Appeal Decision

Appeal Ref: APP/R5510/D/22/3307089

15 Brookside Road, Hillingdon, Hayes UB4 0PQ

- The appeal is made under section 78 of the Town and Country Planning Act 1990 against a refusal to grant planning permission.
- The appeal is made by Mr Jasbinder Sandher against the decision of the Council of the London Borough of Hillingdon.
- The application Ref 30809/APP/2022/1634, dated 19 May 2022, was refused by notice dated 14 July 2022.
- The development proposed is the erection of a first floor side extension, part first floor rear extension and conversion of flat roof to pitch roof on rear single storey extension.

TITLE: Existing and proposed
Side Elevation

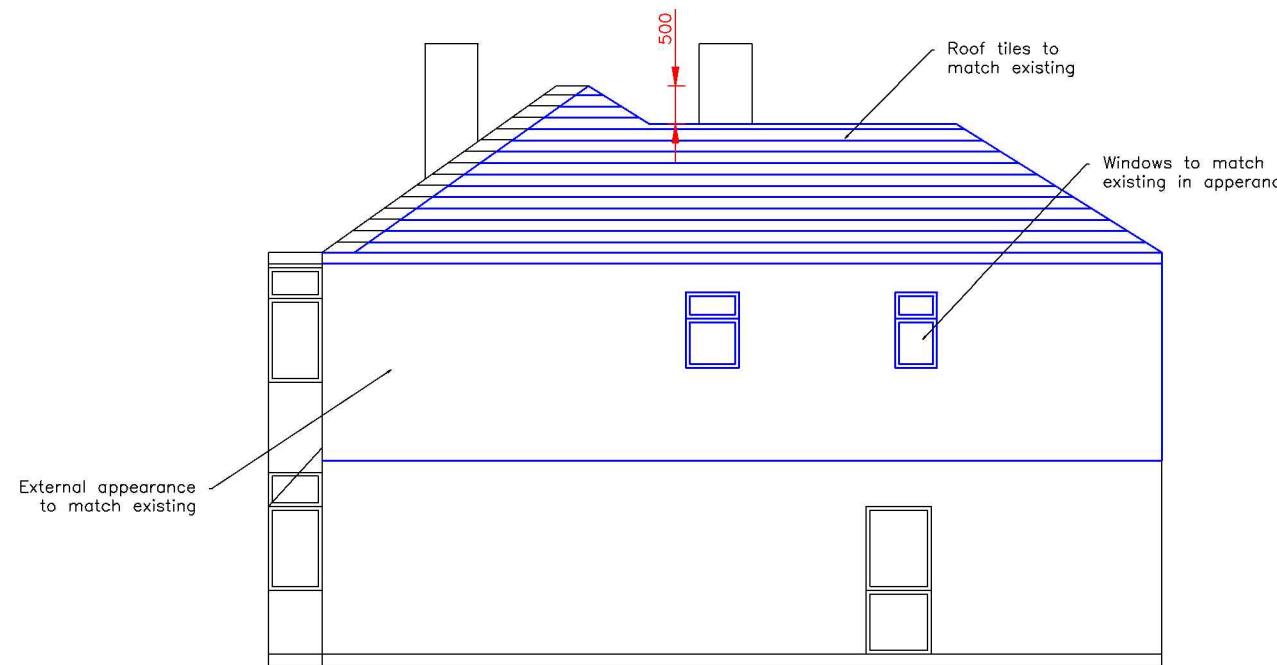
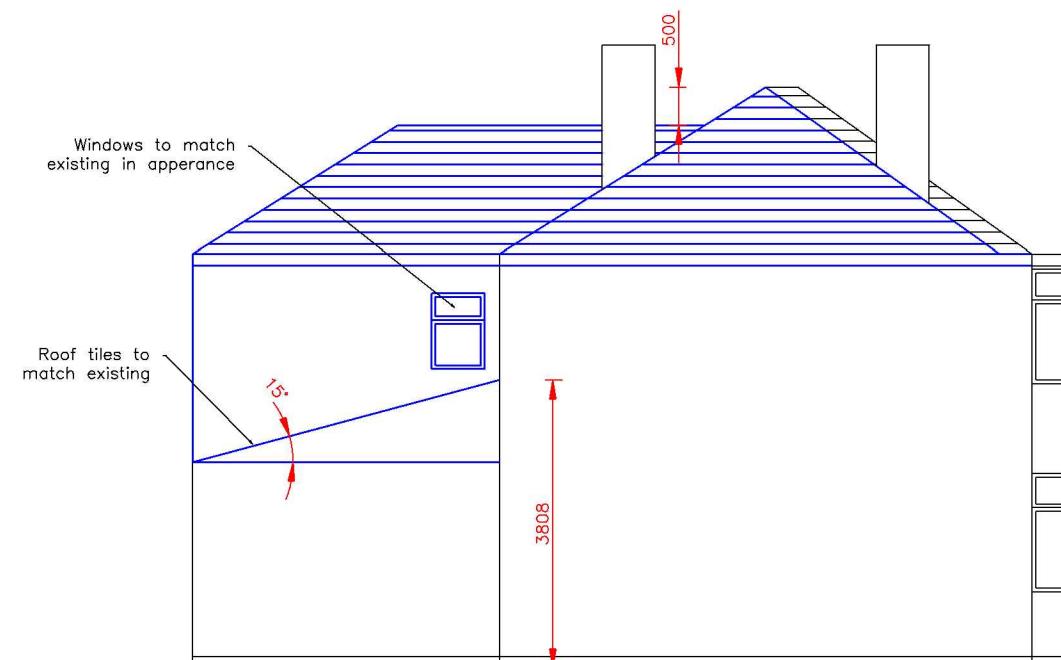
8. The proposal would be set in from the side boundary of the site and, due to its generous rear garden, would retain ample separation from the Dorchester Way properties, with a building line that would follow the curve of the highway. Nevertheless, when viewed from the corner of Dorchester Way it would read as a largely featureless expanse of built form at the corner of the street, further adding to its dominance when viewed from this location.

REV:	DESCRIPTION:	BY:	DATE:
STATUS: Planning			
CLIENT: Mr Jas Sandher 15 Brookside Road Hayes UB4 0PH			
DRAWN BY:			
SITE: 15 Brookside Road			
TITLE: Existing and Proposed elevations			
SCALE AT A3:	1:100	DATE:	16.05.2022
PROJECT NO:	DRAWING NO:	REVISION:	P1
0019	0019-001

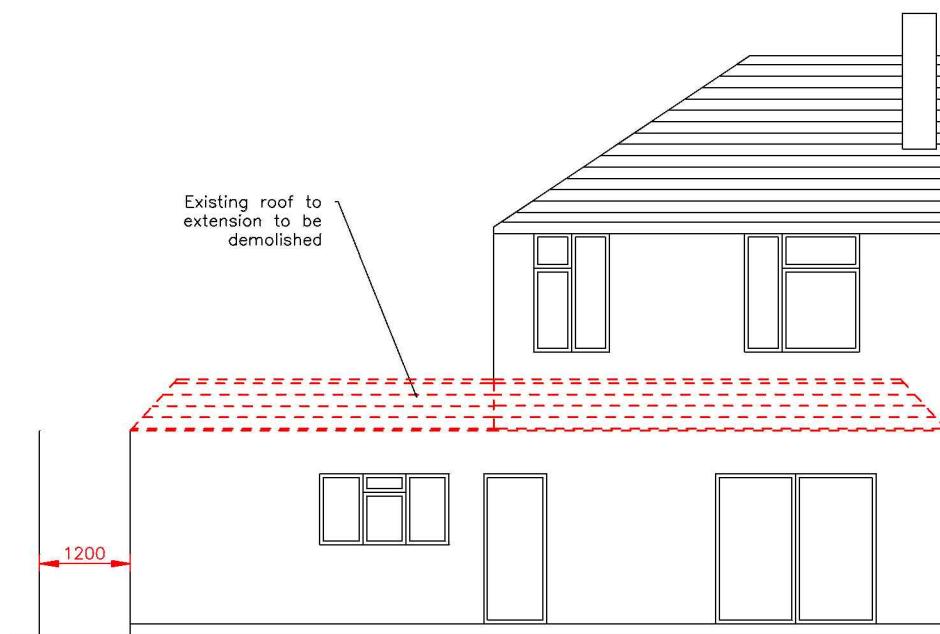
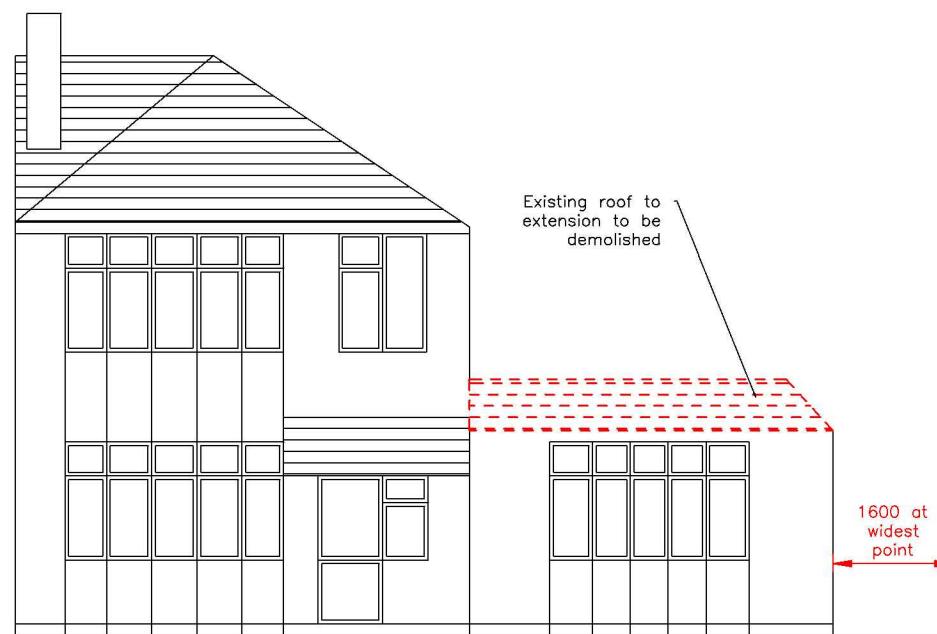
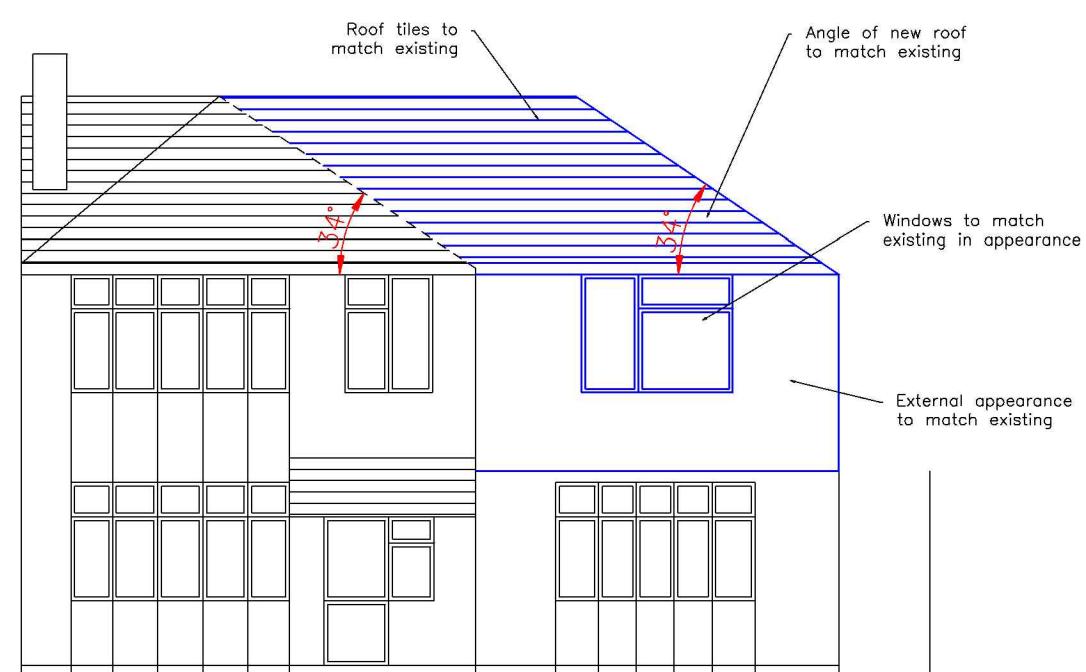
5. The materials and fenestration details of the proposal would complement the dwelling. The extension would be built flush with the existing front elevation, with an eaves and ridge height that would match the current roof along the front and side, while set down at the rear. Due to its positioning above the current side extension, it would not alter the overall footprint of the dwelling.

6. However, the proposal would span the full front width of the side extension and match its depth, and would introduce a pitched roof to the rear extension, adding significant bulk to the property. Although the side extension already exceeds half the width of the property, the introduction of the built form of the

proposal would be an overwhelming addition, failing to appear subordinate or to respect the original character and proportions of the dwelling.

7. Due to its corner positioning and the adjacent green space, the site occupies a prominent plot in the surrounds where, even acknowledging surrounding trees and the overgrown nature of the open area, it is highly visible in the immediate locality. The proposal would therefore be a prominent addition at the site, with its added bulk reading as unduly dominant in the surrounds. Its infill of the gap at first floor level on this end of the terrace would reduce the openness adjacent to the green space and unbalance this row of dwellings, such that it would appear as an awkward and out of place feature in context.
